Job No: BP#2014-01802
 11 Leeman
 Street

ONE AND TWO FAMILY	PLAN REVIEW	CHECKLIST
Soil type/Presumptive Load Value (Table R401.4.1) _____		
Component	Submitted Plan	Findings/Revisions/Dates
STRUCTURAL		
Footing Dimensions/Depth (Table R403.1 & R403.1(1), (Section R403.1 & R403.1.4.1)	Requested clarification of sonotube layout.	OK per plan revisions
Foundation Drainage, Fabric, Damp proofing (Section R405 & R406)	NA	
Ventilation/Access (Section R408.1 & R408.3) Crawls Space ONLY	NA	
Anchor Bolts/Straps, spacing (Section R403.1.6)	Provide size of anchor bolts.	OK per plan revisions
Lally Column Type (Section R407)	NA	
Girder & Header Spans (Table R502.5(2))	NA	
Built-Up Wood Center Girder Dimension/Type	NA	
Sill/Band Joist Type & Dimensions	NA	
First Floor Joist Species Dimensions and Spacing (Table R502.3.1(1) & Table R502.3.1(2))	NA	
Second Floor Joist Species Dimensions and Spacing (Table R502.3.1(1) & Table R502.3.1(2))	NA	
Attic or additional Floor Joist Species Dimensions and Spacing (Table R802.4(1) and R802.4(2))	NA

A5 BUILDING
SECTIONS

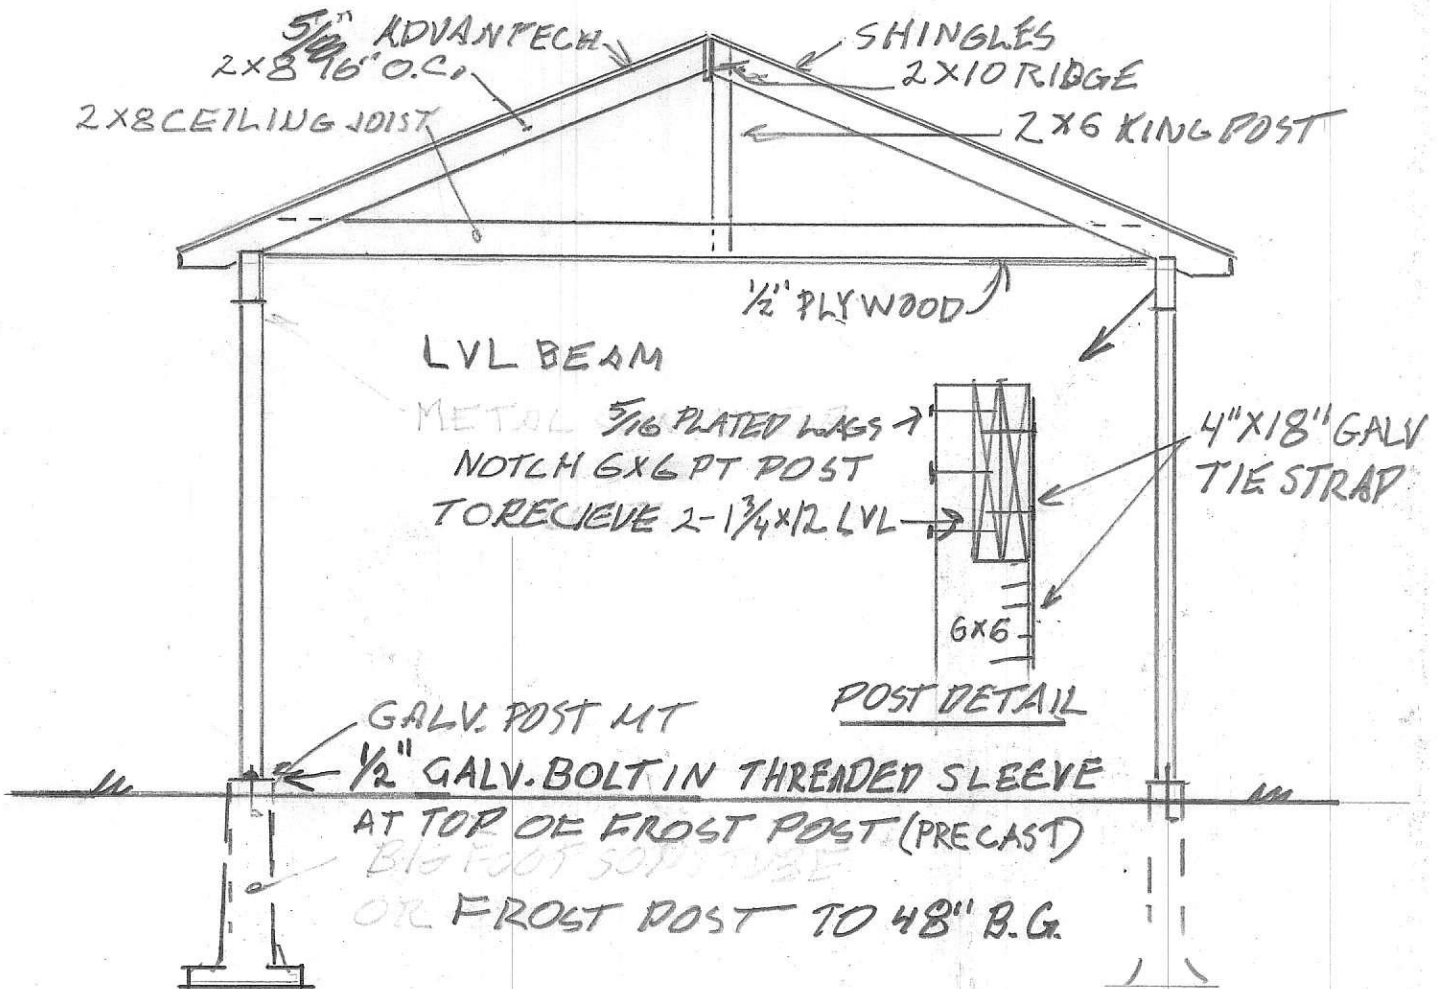
Pitch, Span, Spacing & Dimension (Table R802.5.1(1) - R 802.5.1(8)) Roof Rafter; Framing & Connections (Section R802.3 & R802.3.1)	Size and spacing OK per plans.	
Sheathing; Floor, Wall and Roof (Table R503.2.1.1(1))	Requested roof sheathing be changed to 5/8".	OK per plan revisions.
Fastener Schedule (Table R602.3(1) & (2))		
Private Garage (Section R302.5) Living Space (Above or beside)?	NA	
Table R302.6 Fire separation (Section R302.6)	NA	
Opening Protection (Section R302.5.1)	NA	
Emergency Escape and Rescue Openings (Section R310)	NA	
Roof Covering (Section R905)	Ashpalt shingles OK per plans.	
Safety Glazing (Section R308)	NA	
Attic Access (Section R807)	NA	
Chimney Clearances/Fire Blocking (Chap. 10)	NA	
Header Schedule (Tables R502.5(1) & (2))	NA	
Energy Efficiency IECC, 2009 R-Factors of Walls, Floors, Ceilings, Building Envelope, U-Factor Fenestration Ventilation of Space per ASRAE 62.2, 2007	NA
